TR010064: Application by National Highways for the M60/M62/M66 Simister Island Interchange Project

The Examining Authority's Written Questions and requests for further information

Issued on 17 December 2024

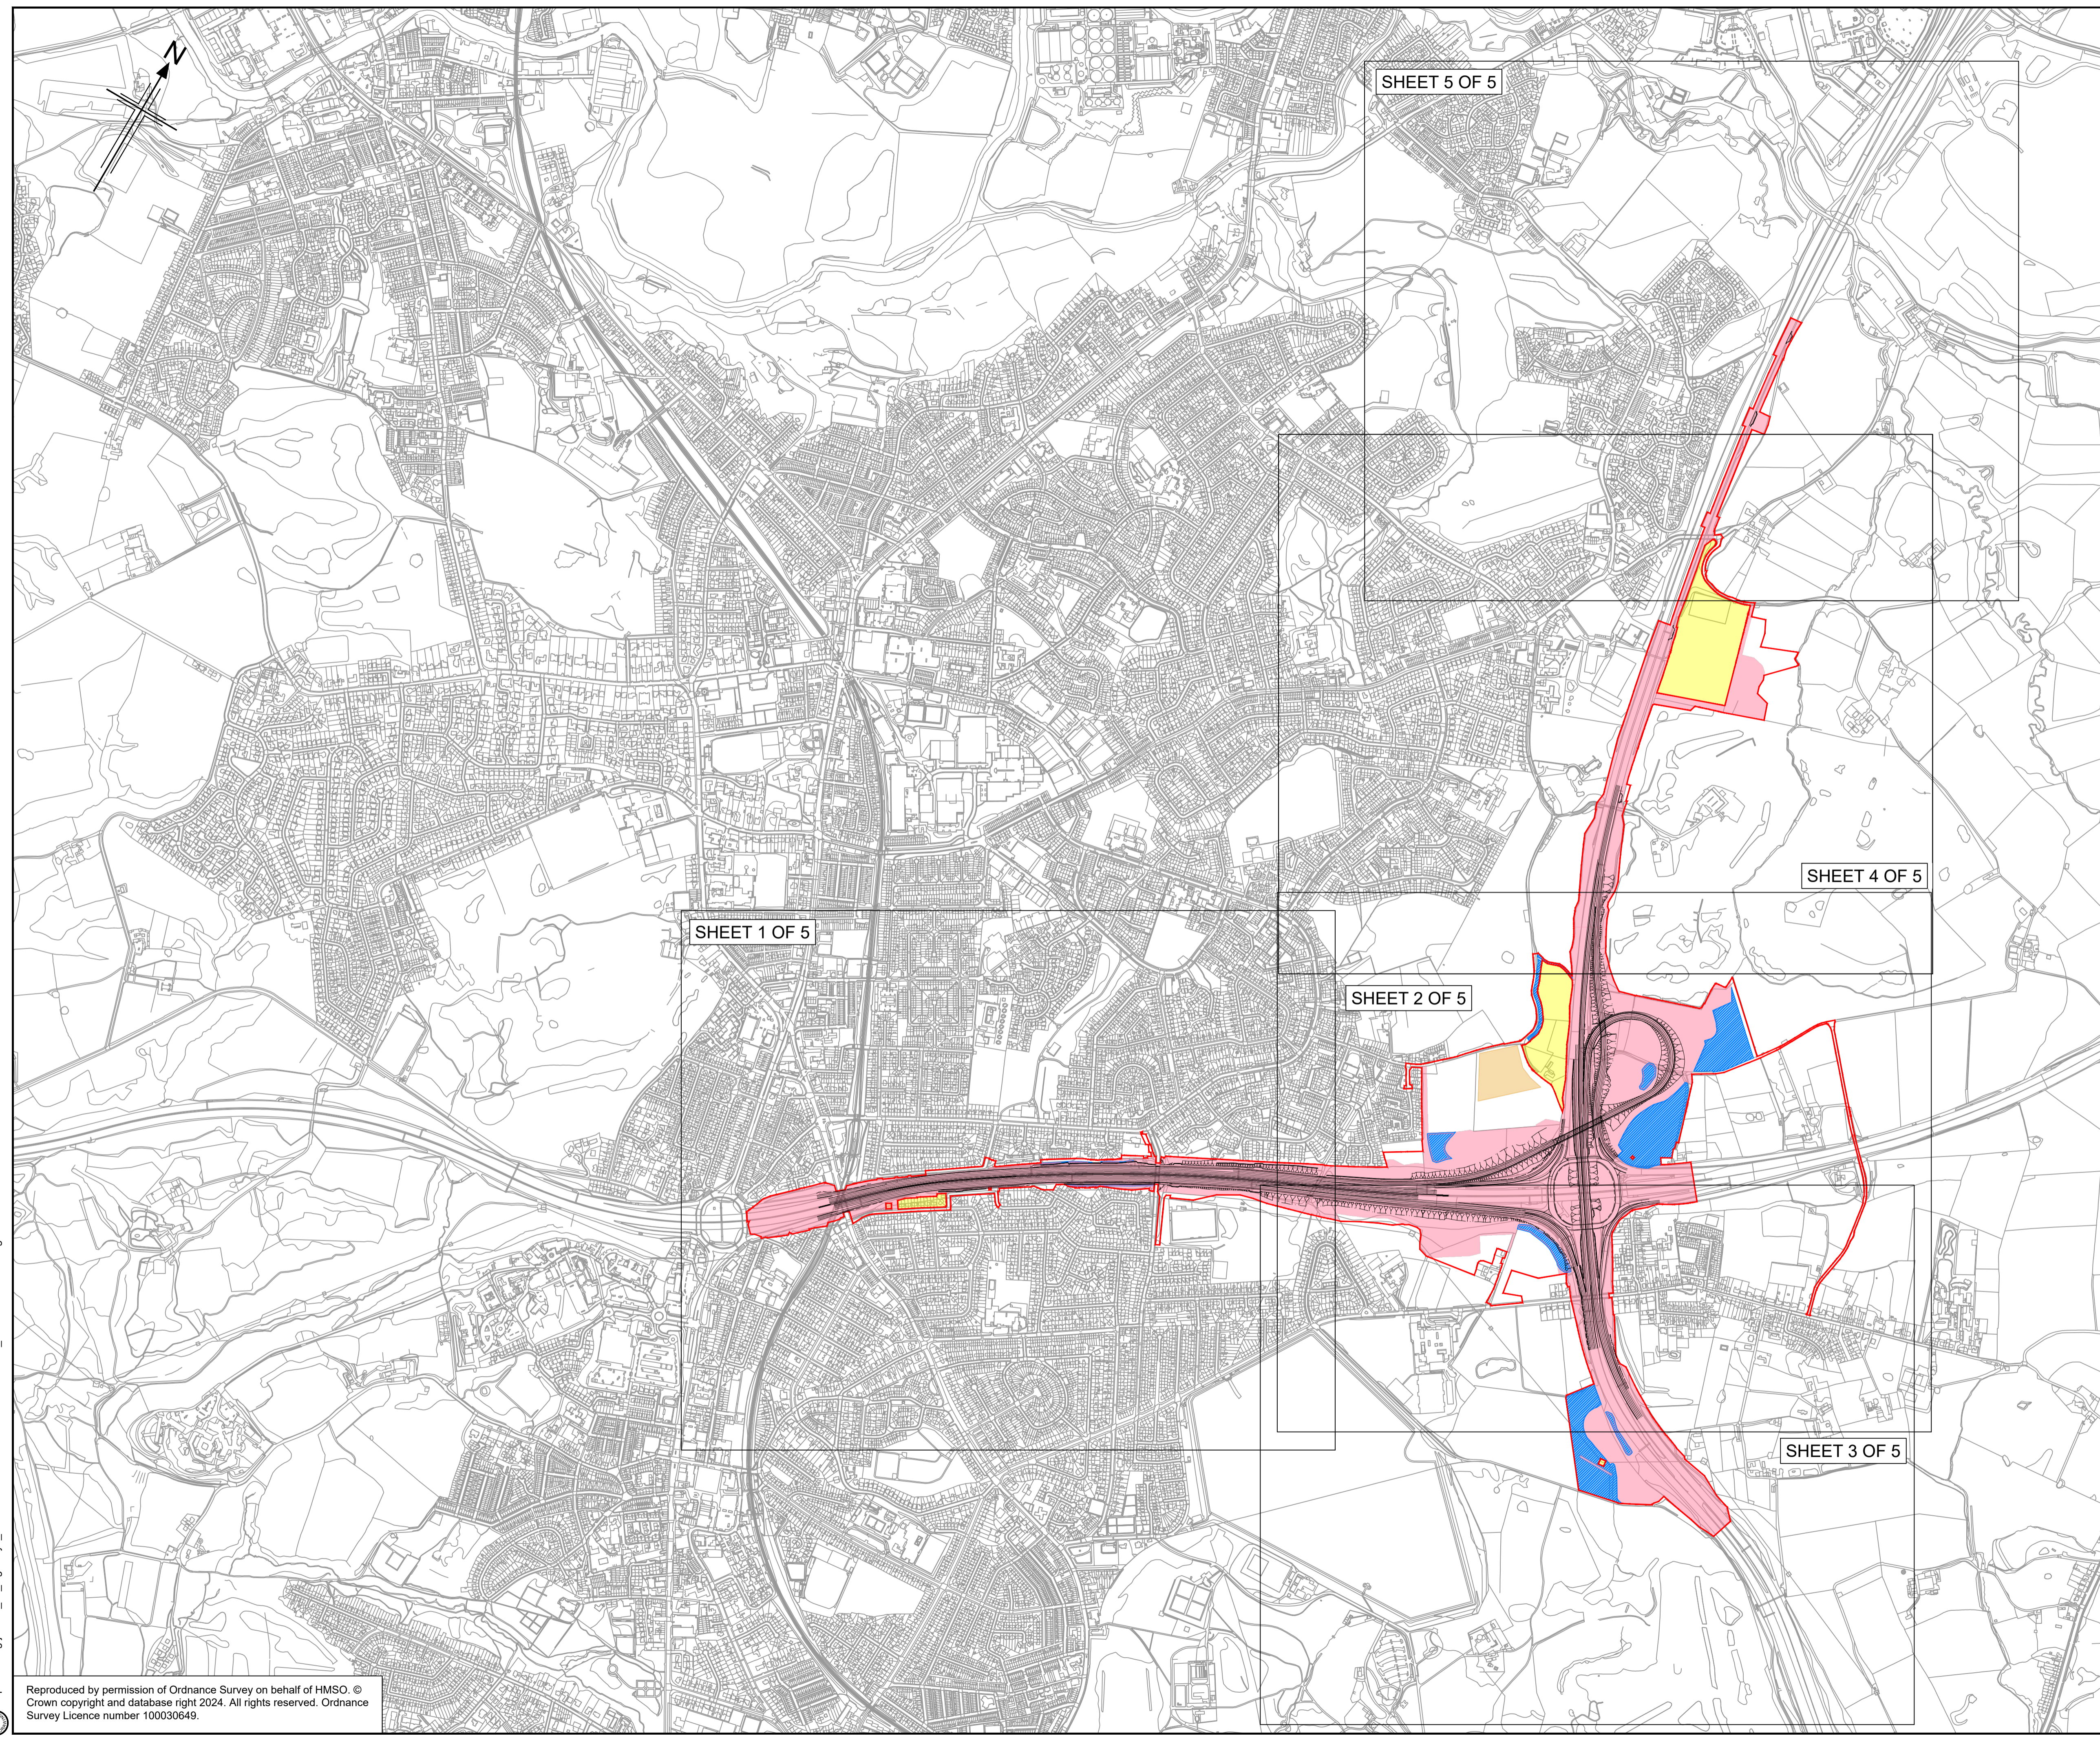
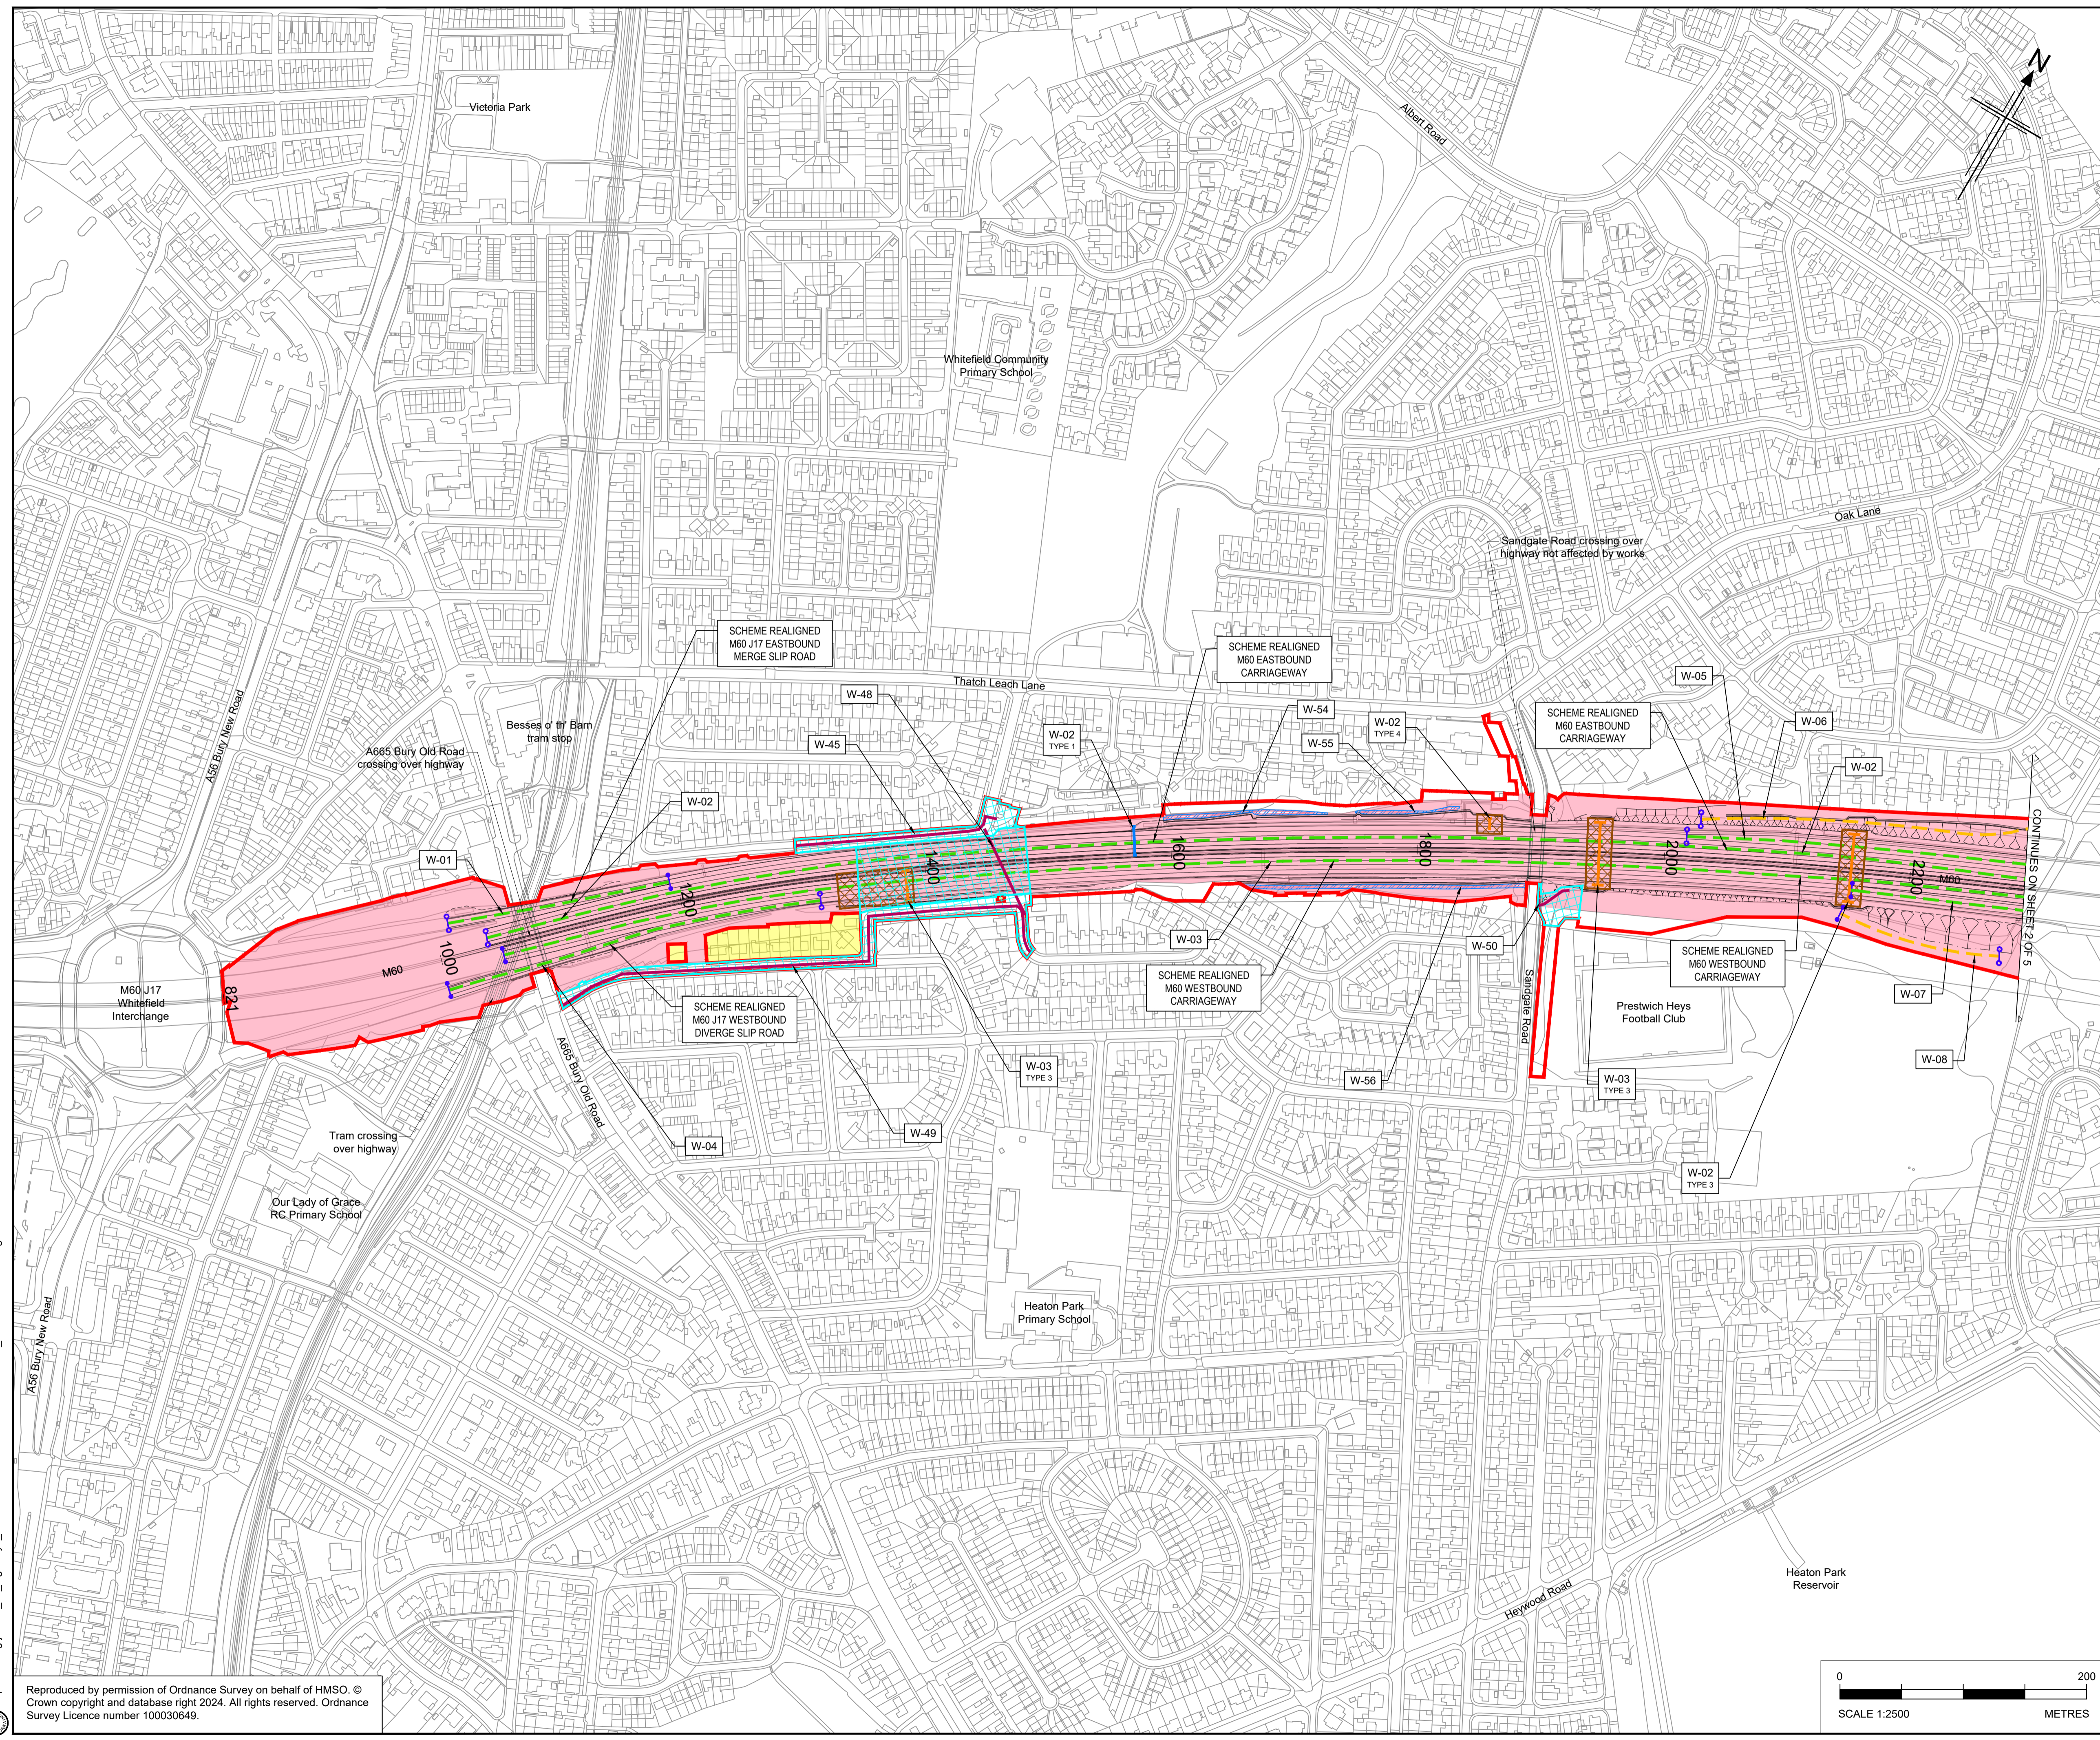
| CA.2.5 | Applicant | <p>Plot 1/1a</p> <p>In CAH1 the applicant explained that the whole of Plot 1/1a was within the ‘limits of highway deviation’ as indicated by pink shading on the Works Plans [AS-006]. The termination of the linear works (indicated by dumbbells) is shown on the Works Plans to be at the very eastern extent of Plot 1/1a. Explain why the entirety of Plot 1/1a is required for permanent acquisition, which includes carriageway beyond the termination of the linear works, and also land to the north and south of the M60 outside the existing slip roads and verge.</p> |
